From: Mark Bassett [REDACTED]
Sent: 01 April 2021 18:30
To: Polly Harris-Gorf
Cc: [REDACTED]
Subject: H02-0095-21 Land to the South of James Road North of A16, Crowland
Attachments: We sent you safe versions of your files; CROWLA - WPS-PPL-005-P-02D_Block Plan A1.pdf; CROWLA - WPS-PPL-005-P-03B_Existing Site Layout Plan A1.pdf; CROWLA - WPS-PPL-005-P-04E_Proposed Site Layout Plan 1-400 A1.pdf; CROWLA - WPS-PPL-005-P-05C_Proposed Site Layout Plan - HGV Only 1-200 A1 (1).pdf; CROWLA - WPS-PPL-005-P-06E_Proposed Site Layout Plan - PFS Only 1-200 A1.pdf; CROWLA - WPS-PPL-005-P-07C_Proposed Site Elevations A1.pdf; CROWLA - WPS-PPL-005-P-08D_Proposed Building Plans A1.pdf; CROWLA - WPS-PPL-005-P-09C_Proposed Building Elevations A1.pdf; CROWLA - WPS-PPL-005-P-10C_Proposed Site Finishes Layout Plan A1.pdf; CROWLA - WPS-PPL-005-P-11C_Swept Path Analysis Plan A1.pdf; CROWLA - WPS-PPL-005-P-15B_Sections A-A B- B and C-C A1.pdf; Planning Amendment Form 1-4-21.pdf

I write in response to the Parish Council's comments and to provide some amended and additional drawings.

Proposed Site Layout Plan
Scale 1:400

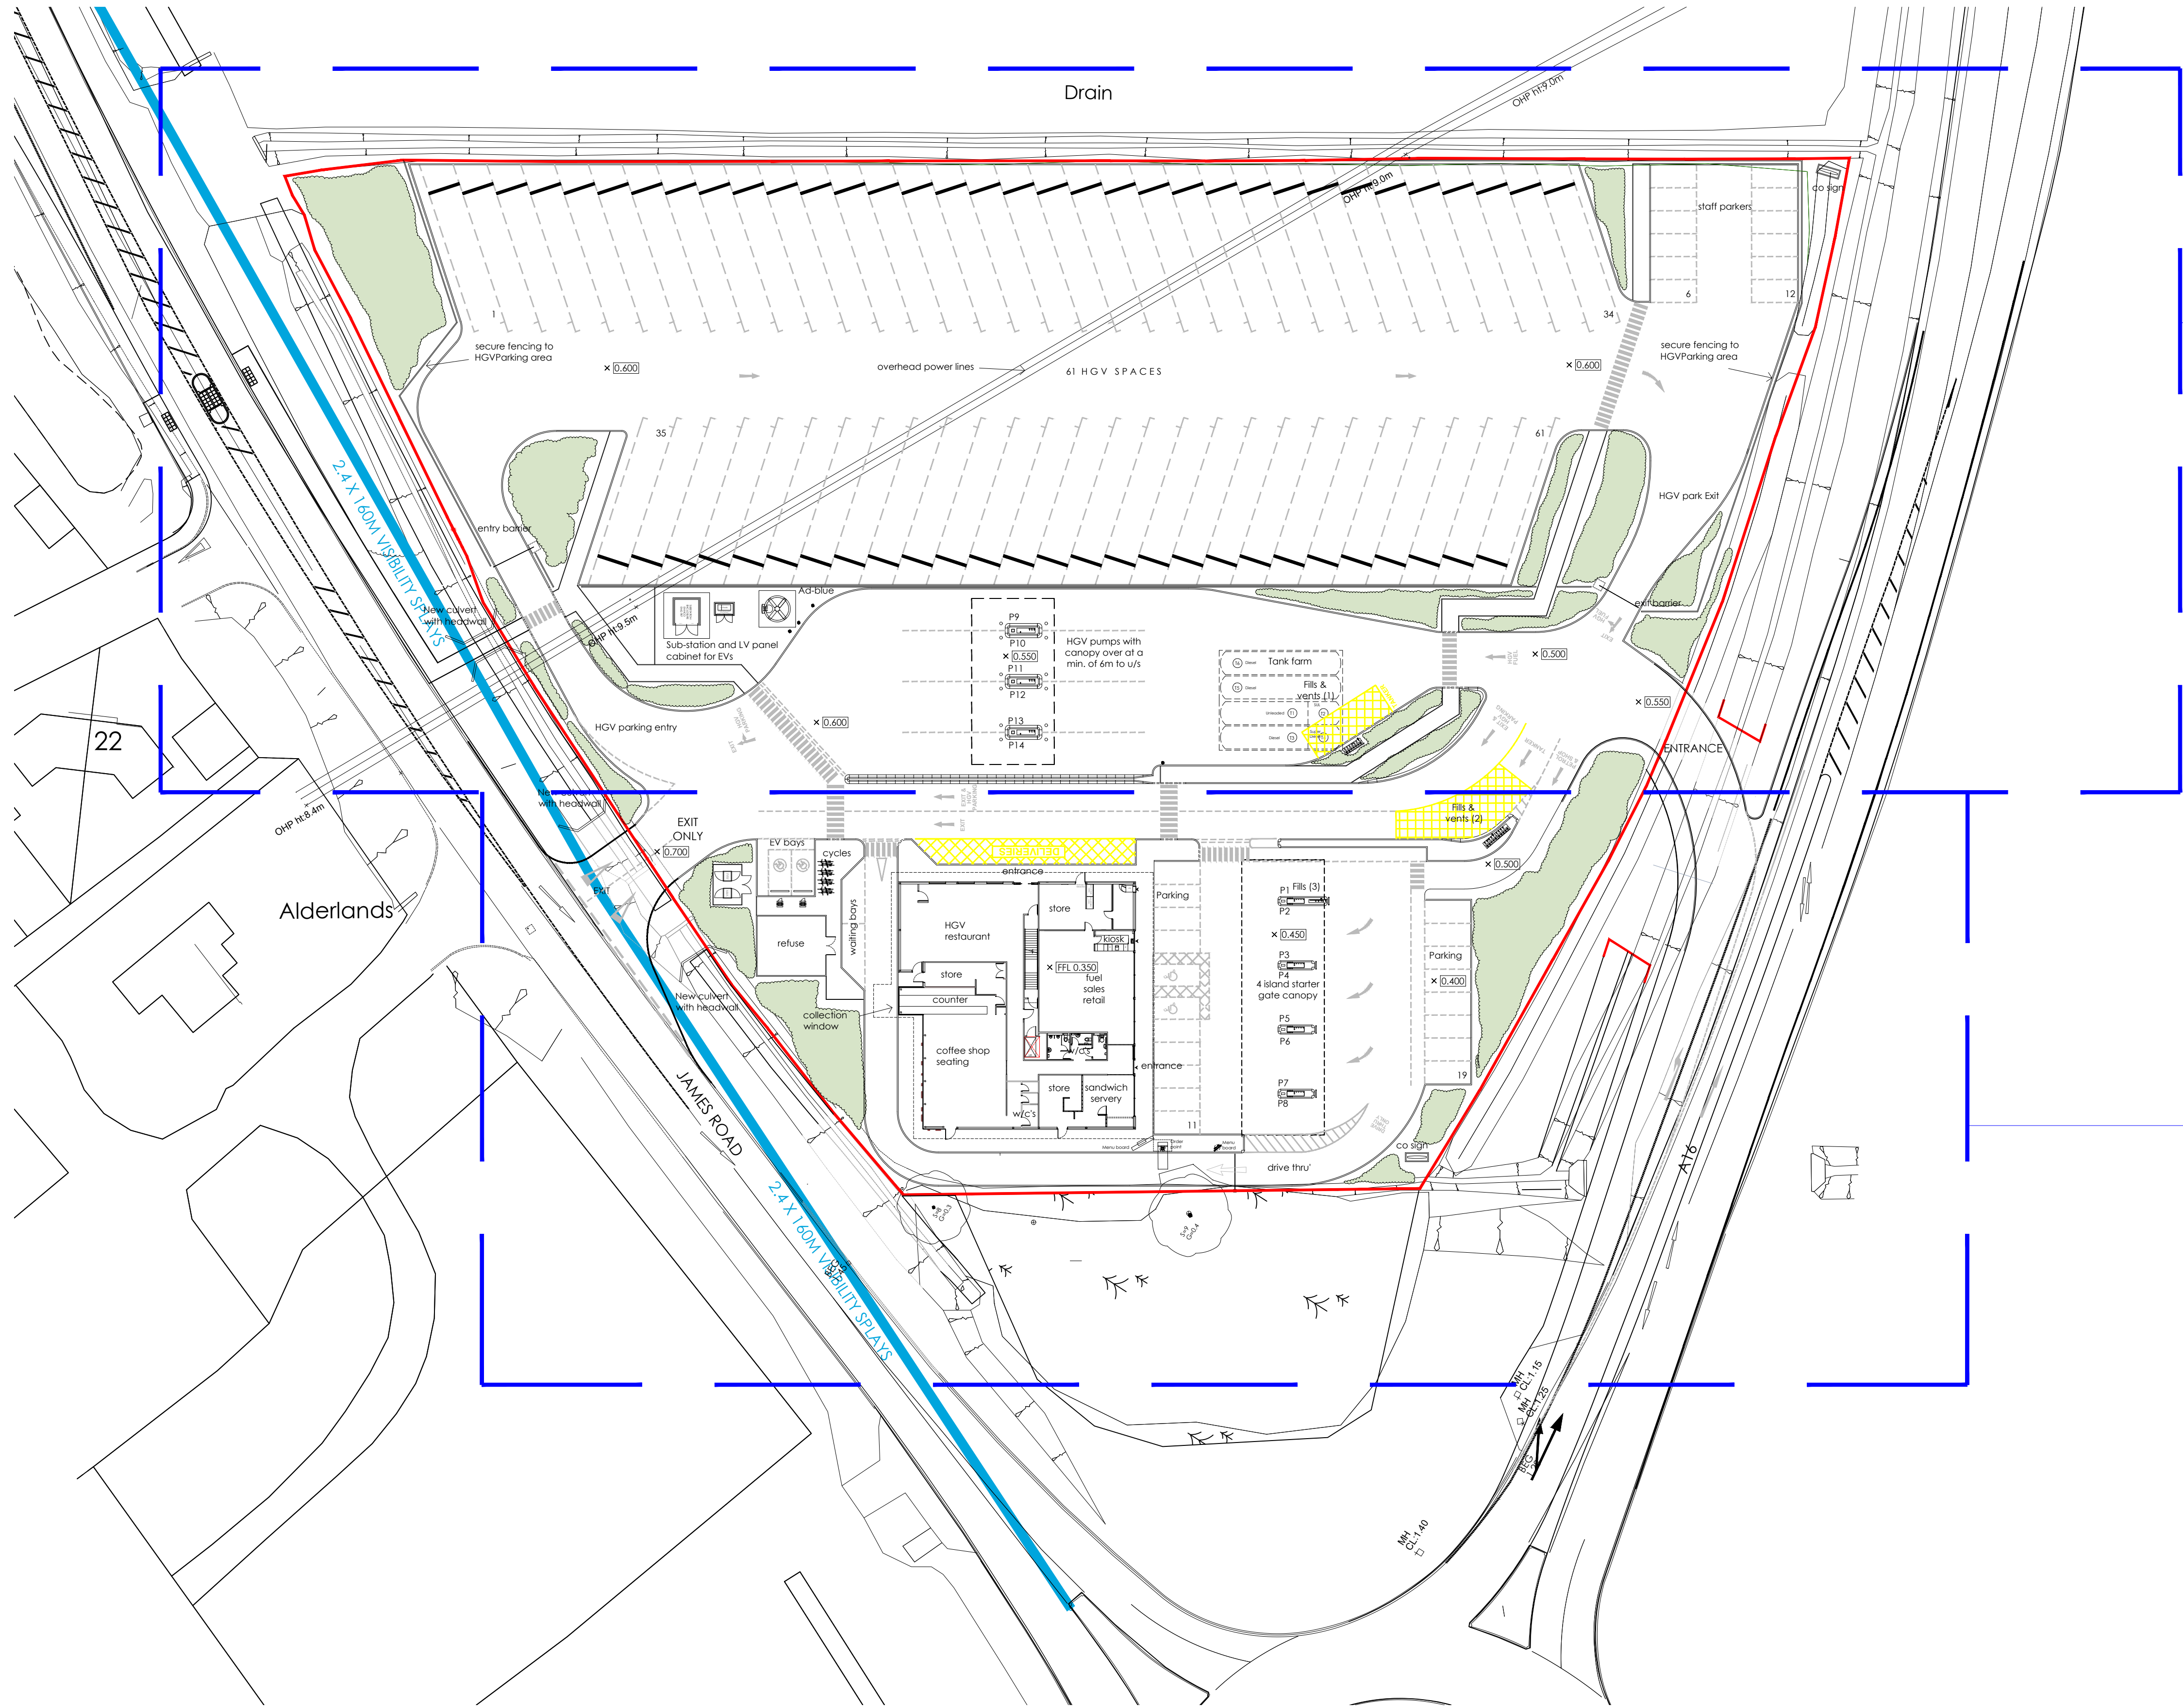
1. We have denoted on the layout the lorry parking bays designated for refrigerated lorries. These comprise the 20 spaces to the south east of the lorry park, closest to the A16 and furthest from residential properties. I confirm that we would be happy for a condition on this matter.

3. We have included a minor variation to the internal road layout, so that it is easier for users of the site to navigate where they need to go following their entrance from the A16.

4. In response to comments from Crowland Caravans we have adjusted the kerbs in and out of the drive thru lane and have removed the canopy above the payment window. We have also added tracking for a caravan through the forecourt. In addition, in respect of caravan/motorhome parking, we are aware of a scheme at Sutterton whereby such vehicles are able to park in the HGV park for free for a limited time period. Our client is happy to provide a similar service on this site.
